**From:** [Griffiths, Bryn](#)  
**To:** [Wylfa Newydd](#)  
**Cc:** [Wylfa Newydd DCO](#); [Energy Island](#); [Aron, Henry](#)  
**Subject:** Natural Resources Wales: Deadline 4 submission - Wylfa Newydd Nuclear Power Station (Our ref: 20011606)  
**Date:** 17 January 2019 15:36:27  
**Attachments:** [2019 01 17 Deadline 4 submission - NRW.PDF](#)

Deadline 4 submission, including NRW's case put orally at the January ISHs – Our ref: 20011606

### **GORSAF BŴER NIWCLEAR ARFAETHEDIG WYLFA NEWYDD / PROPOSED WYLFA NEWYDD NUCLEAR POWER STATION**

#### **RE: NATURAL RESOURCES WALES' CASE PUT ORALLY AT THE ISSUE SPECIFIC HEARINGS HELD IN JANUARY 2019**

WN0902-HZDCO-LFM-DRG-00024	ECOLOGICAL COMPENSATION SITE, CAE CANOL-DYDD, EXISTING SITE PLAN
WN0902-HZDCO-LFM-DRG-00025	ECOLOGICAL COMPENSATION SITE, CAE CANOL-DYDD, PROPOSED SITE LAYOUT

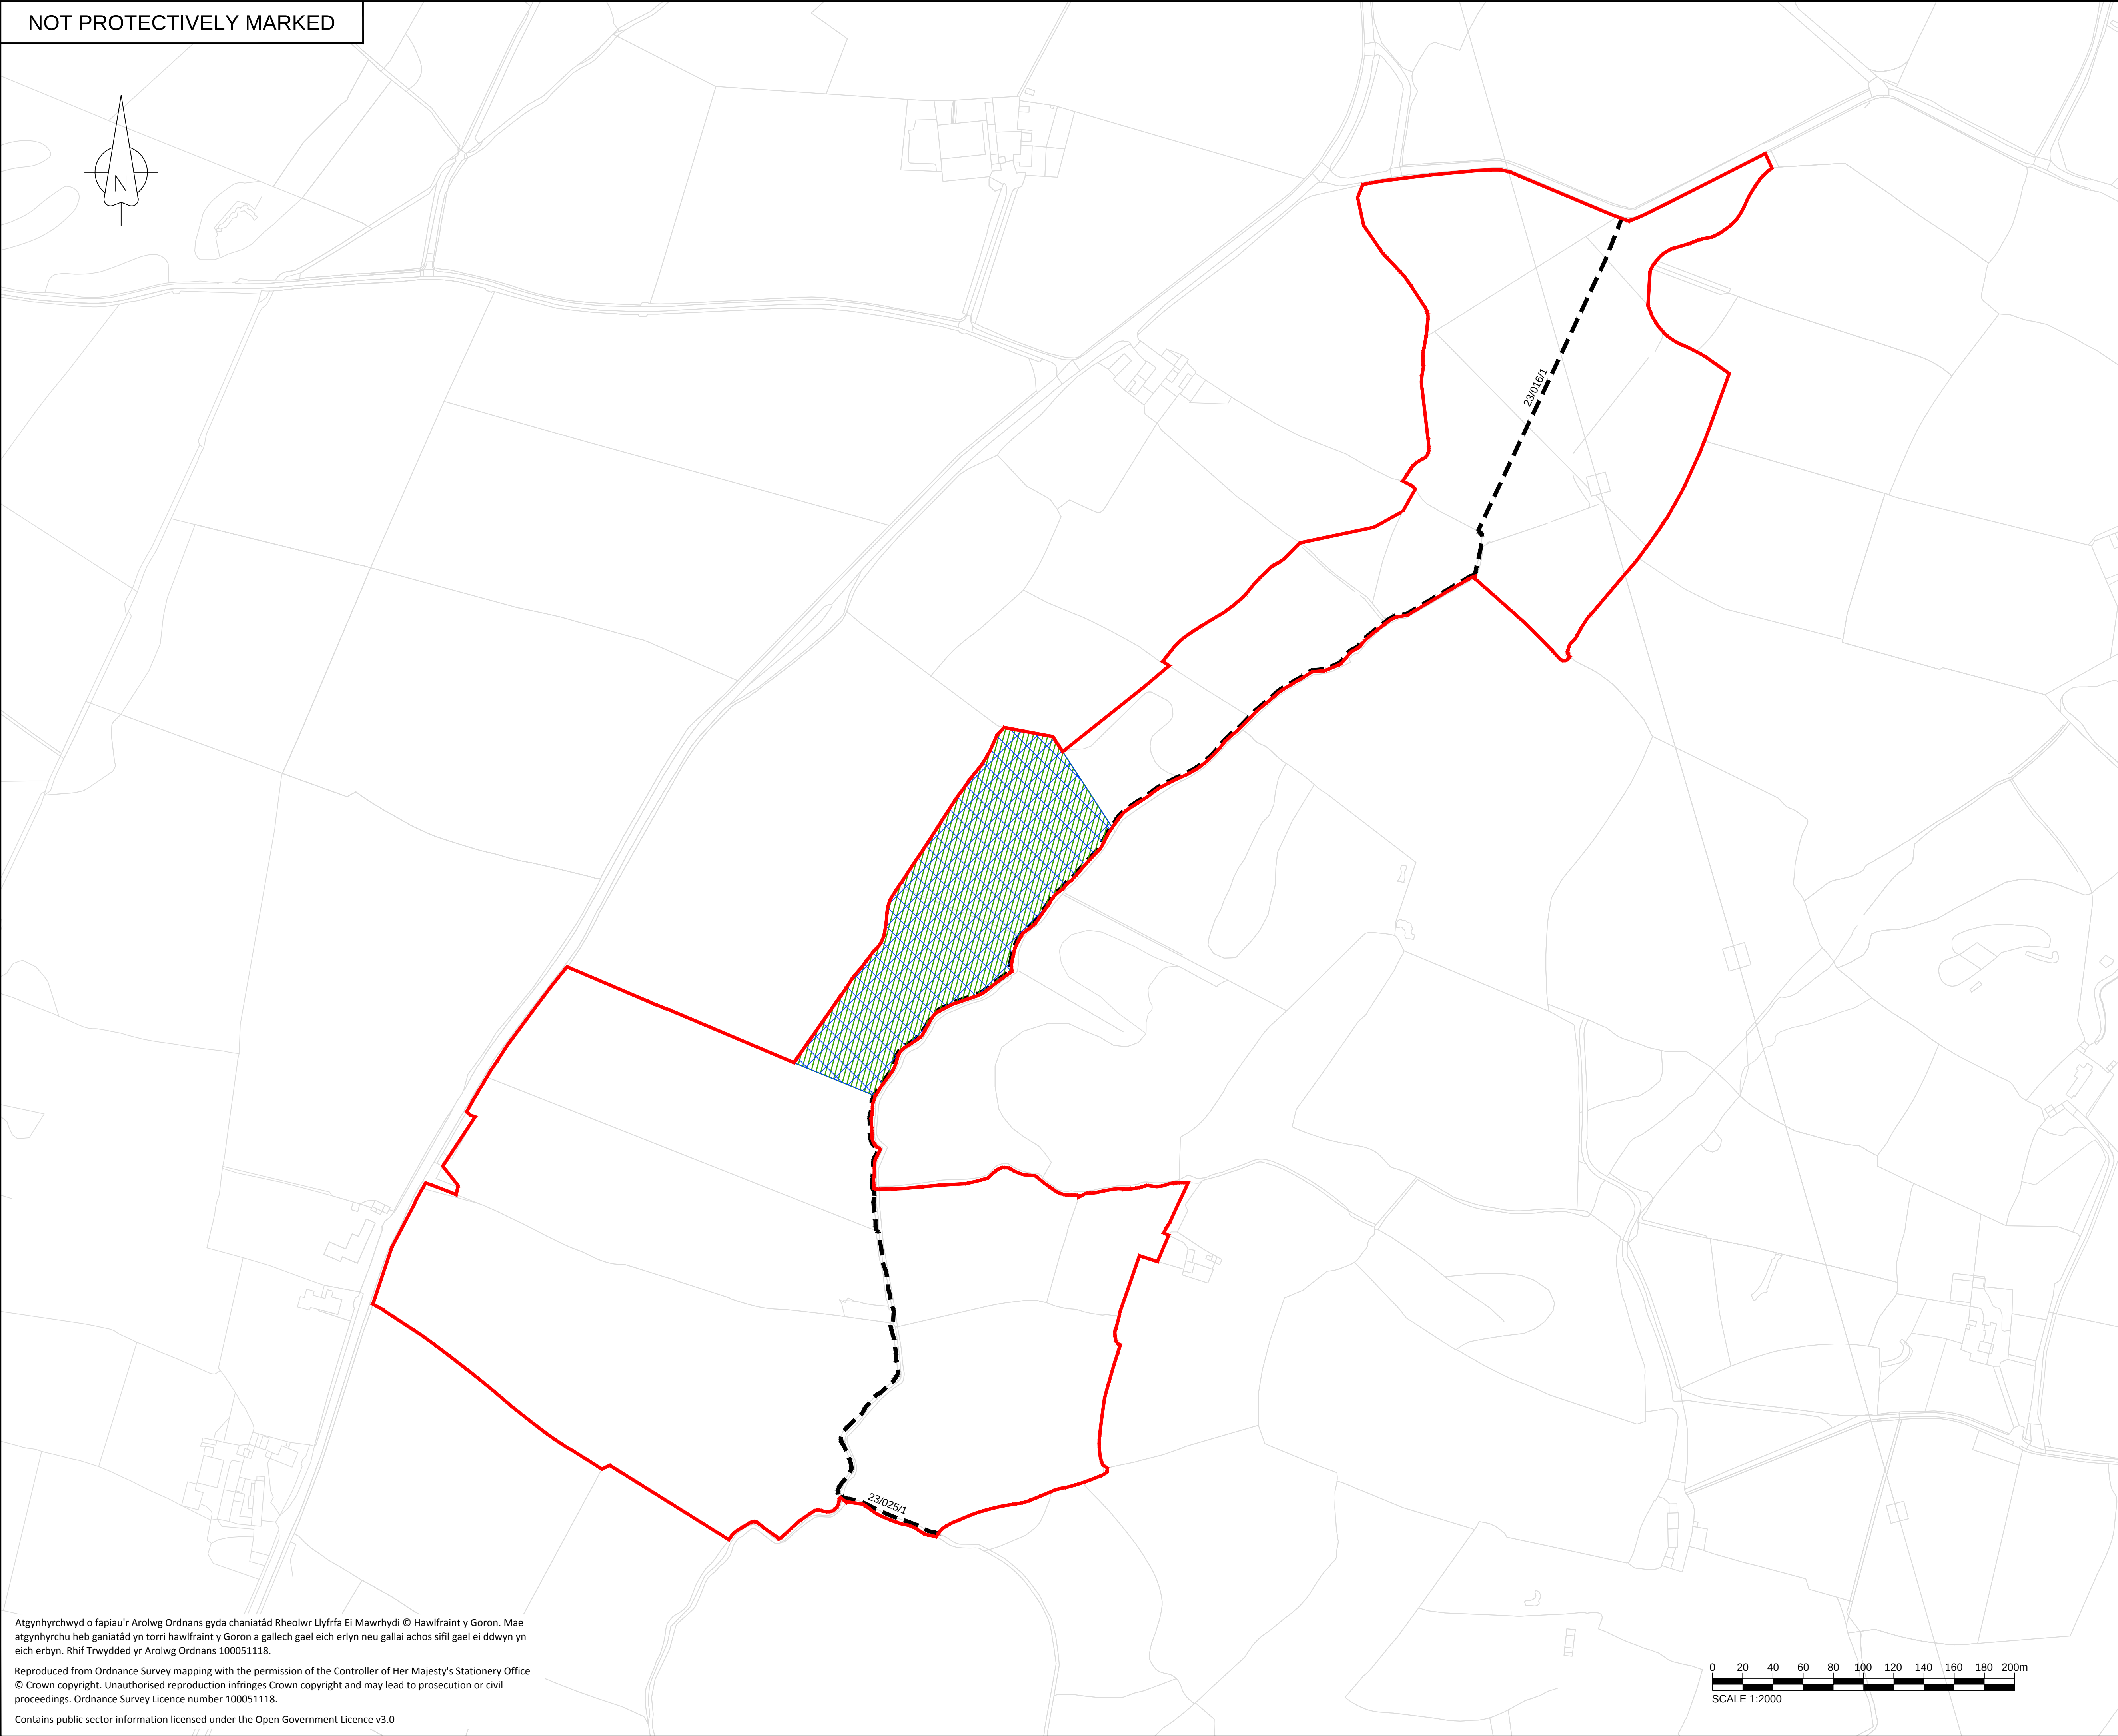
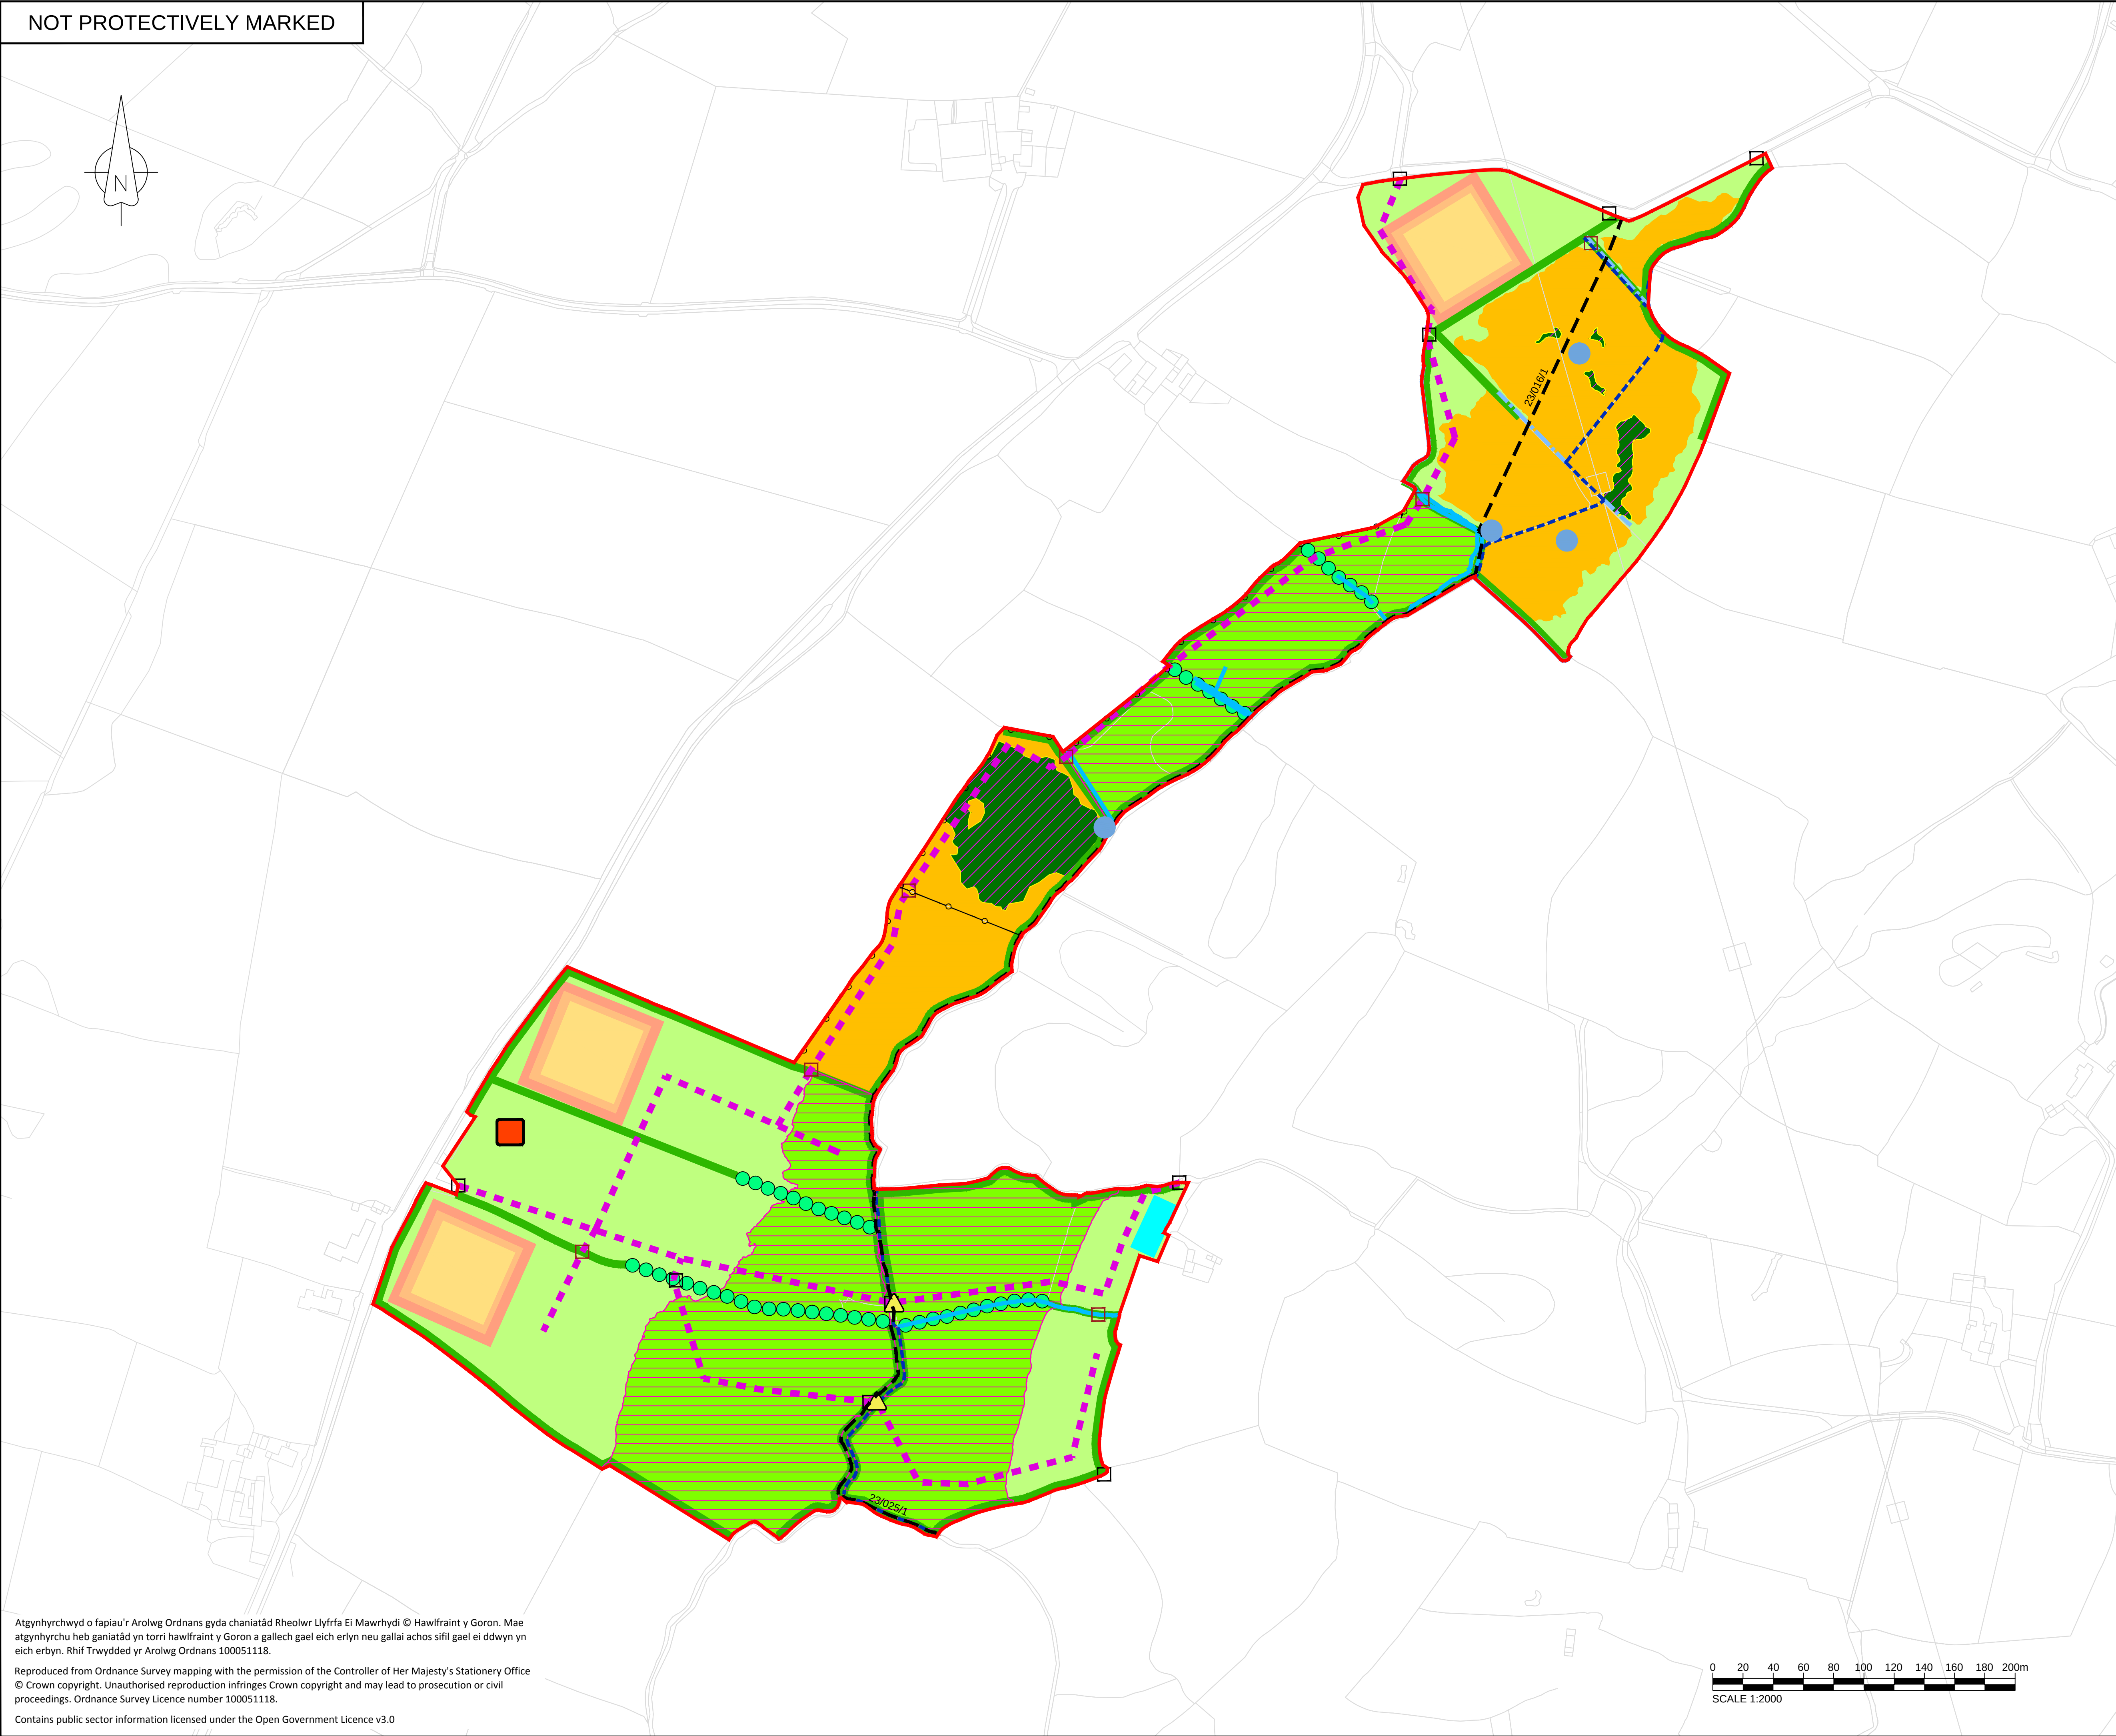
3.12.1. NRW consider that there is insufficient information on the pre-emptive compensation sites (Cors Gwawr and Cae Canol Dydd) to have confidence in the proposals. In particular, hydrological data supplied for these sites is inadequate, which means that their hydrology currently is not adequately understood.

3.12.2. In both cases, there are existing areas of fen which can be enhanced by managing apparent water sources (e.g. springs and streams) so that they are extended to irrigate a larger area. However, there is no adequate data on groundwater regime or streamflow on which to base any projection of the quantity or quality of wetland that could be created.

3.12.3. Preliminary hydrological survey suggests that there are probably groundwater and surface water resources that could provide *some* appropriate conditions to create fen wetland, but this has not been quantified. It is therefore not possible at this time to conclude with confidence that enough water of adequate quality is available to create the proposed fen habitat.
